COUNTY OF HARNETT RESIDENTIAL LAND USE APPLICATION

Woodshire – Lt 215

Re: Status of Improvement Permit Application #08-5-19569

NEW CENTURY HOMES, LLC.
THE CAMBRIDGE
LOT # 215 WOODSHIRE
SCALE: 1"=40'

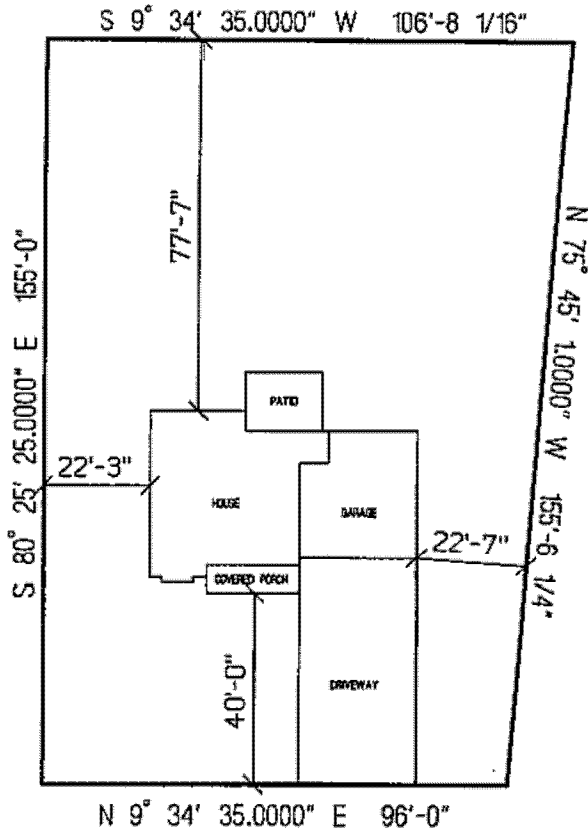
- 1. Property lines/corners not marked or labeled
- 2. House corners not marked or labeled
- 3. Directions not clear to property
- 4. Property needs brush or vegetation removed
- 5. Backhoe pits required
- 6. **Other – Move house as shown on attached sheet. Submit new plot plan to Central Permitting.**
